RE: 73773/APP/2020/3002 - Old Northwood PH

From: Liz Arnold
Sent: 11 December 2020 11:27
To: mshearman@firstplan.co.uk <mshearman@firstplan.co.uk>
Subject: 73773/APP/2020/3002 - Old Northwood PH

I have just received the following comments from the Flood and Water Management Officer, for your consideration.

DRAWING NO. **REVISION**
20114-A-P100

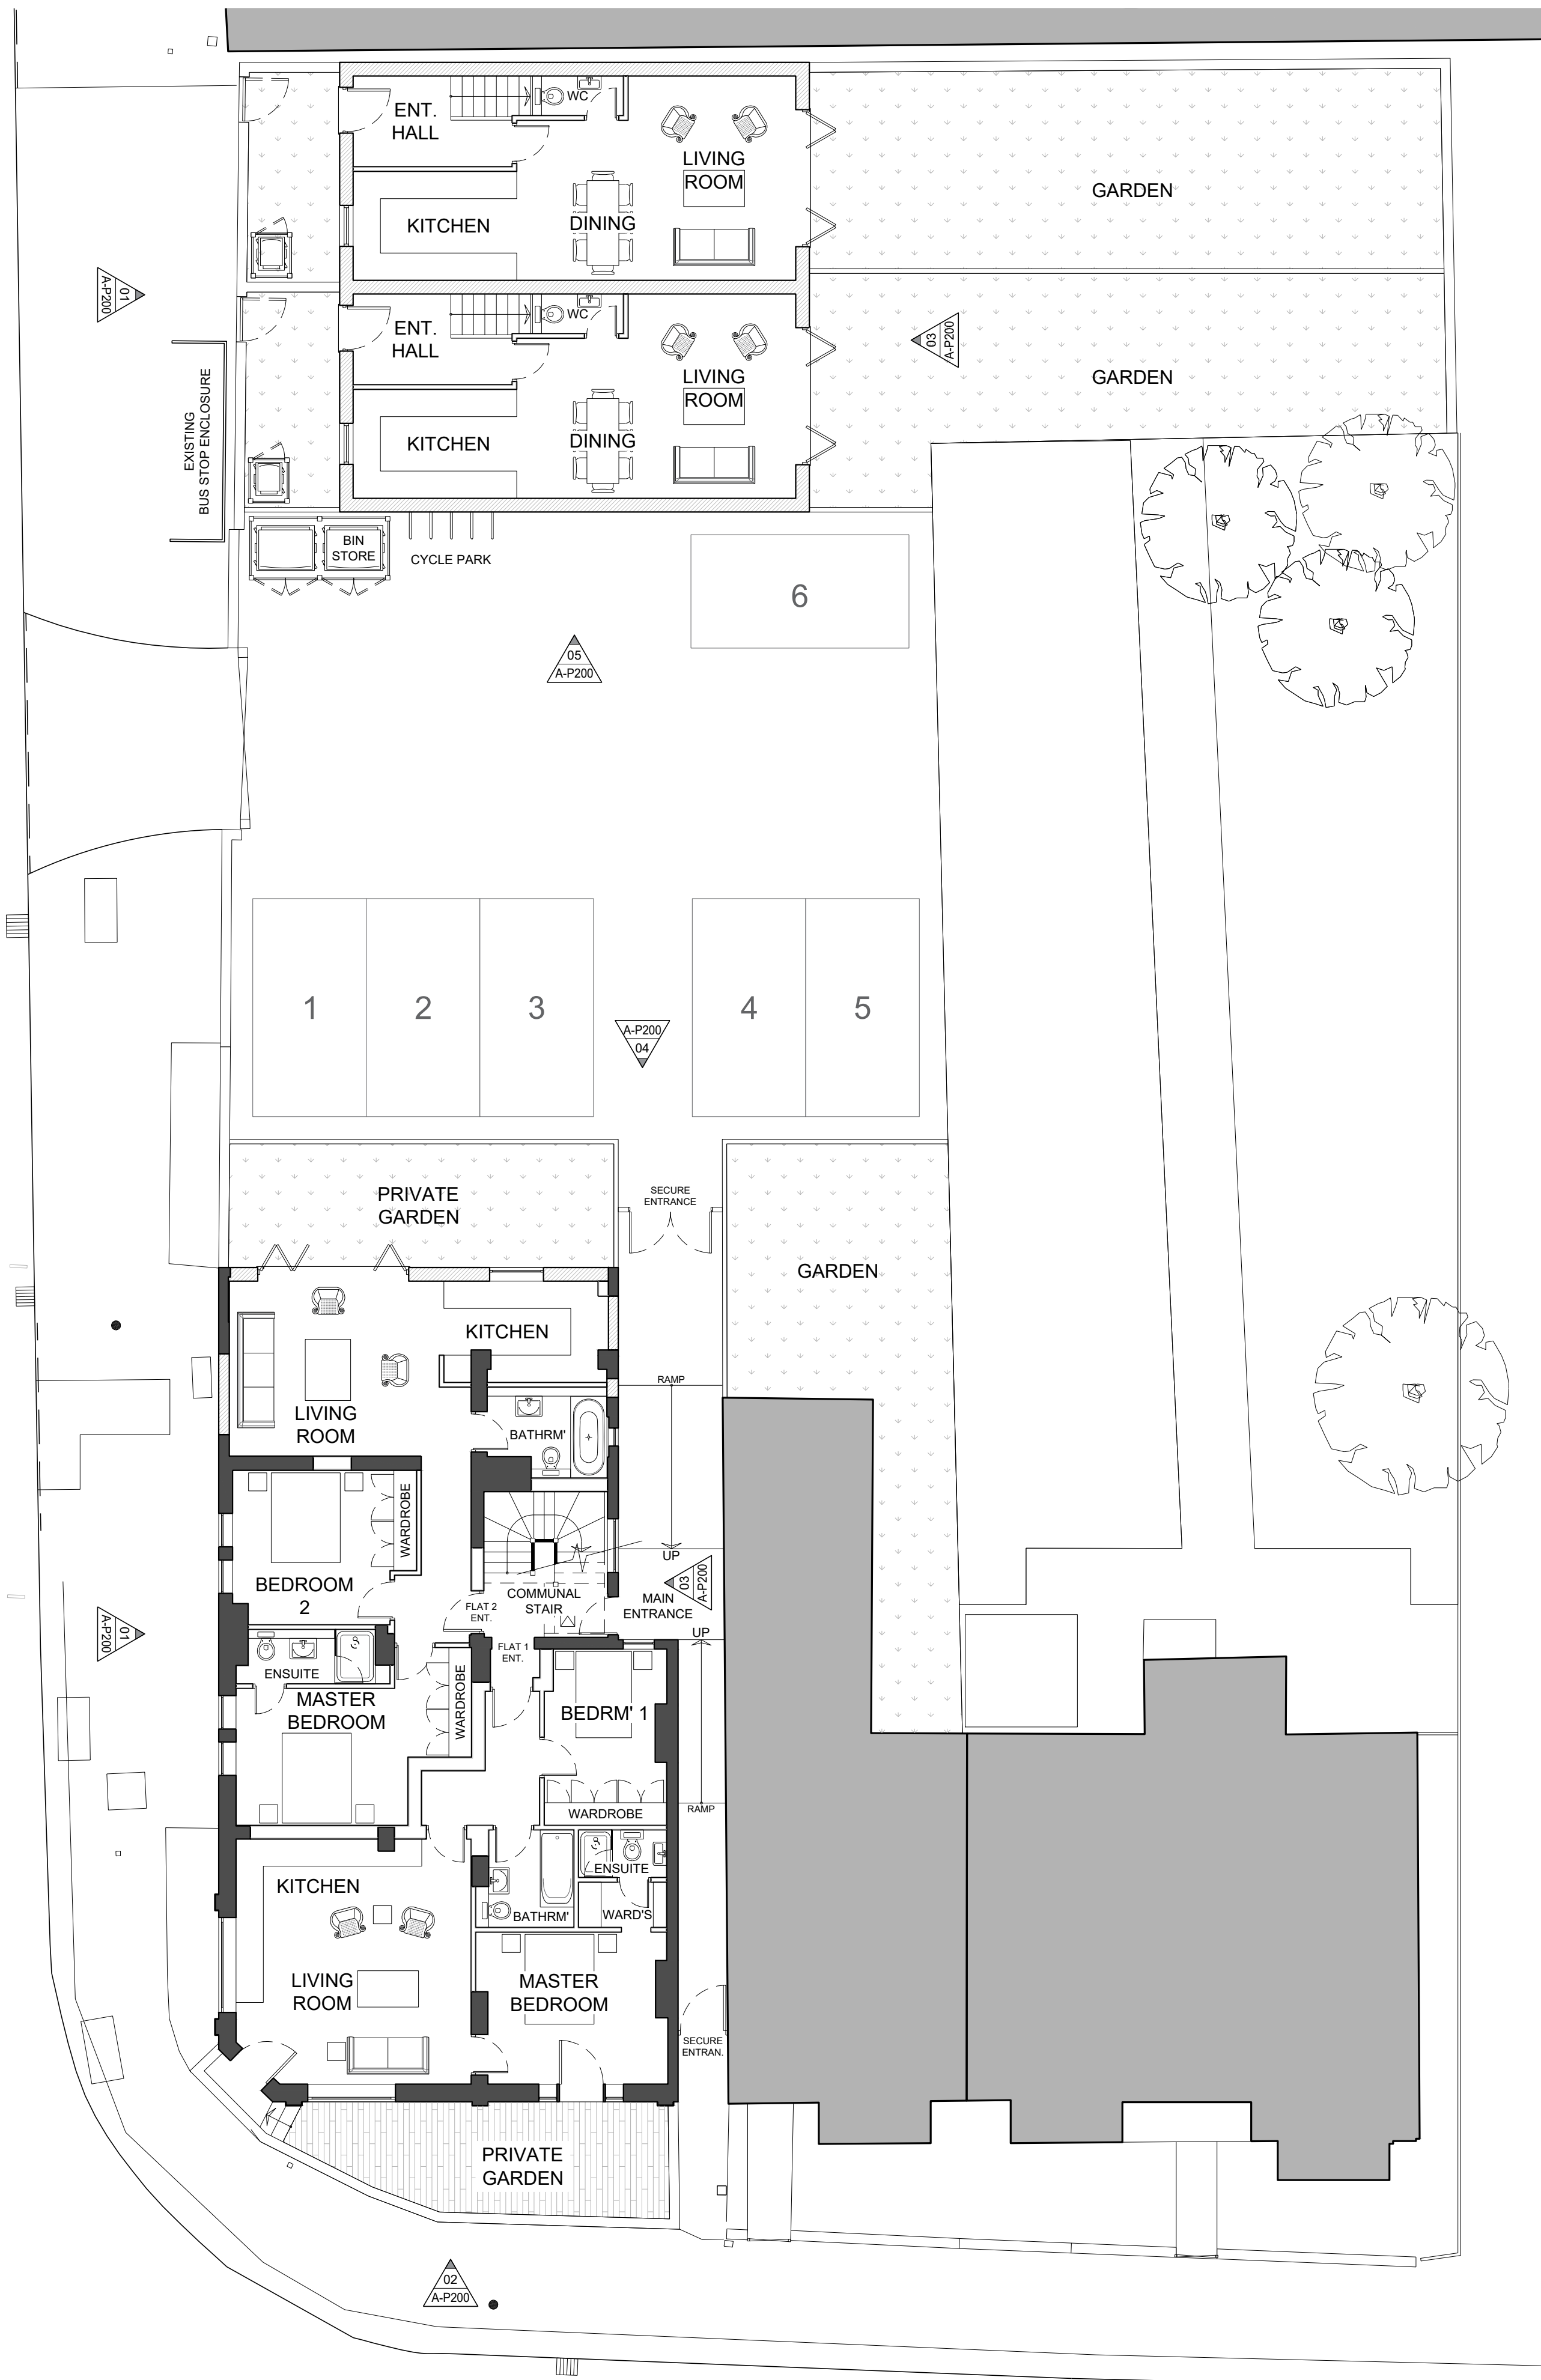
Objection. The proposed location of the two semi-detached properties is at risk of surface water flooding and a flood risk assessment has not been provided. Notwithstanding this, the proposals in this application have greater potential harm than the previous (73773/APP/2019/2660) on flood risk grounds due to the increased extent of built footprint at ground level.

Following your email below, the application Site, as per the Environment Agency Flood Map is located in Flood Zone 1 (low risk) and as such it is not necessary to undertake a Flood Risk Assessment to support the application. Indeed, this was found acceptable in the determination of the previous application (ref: 73773/APP/2019/2660). We understand that the Council's Flood and Water Management Officer has objected on the basis that the proposal now sought *"have greater potential harm than the previous (73773/APP/2019/2660) on flood risk grounds due to the increased extent of built footprint at ground level"*. This conclusion is incorrect; the previous application includes the demolition of the existing building and no. 140 Pinner Road and replacement with 2 separate flatted blocks including an undercroft car park. This resulted in less open space than now proposed. The new scheme does not seek any alteration to no. 140 Pinner Road therefore the existing garden will remain, moreover substantial gardens are included to the two townhouses to the rear of the site and an open car park. This is illustrated clearly in the images below (left current scheme, right previously approved scheme). Not only is this an improvement on the previous scheme but it is an improvement on what is currently on site which is a site covered in hardstanding. The proposal will provide more permeable surfaces at the site which will reduce surface water flooding risk. On this basis the scheme should be considered acceptable.

It is noted that the previous application included a condition requiring sustainable water management/ SuDs it is anticipated a similar condition would be attached to a consent again now.
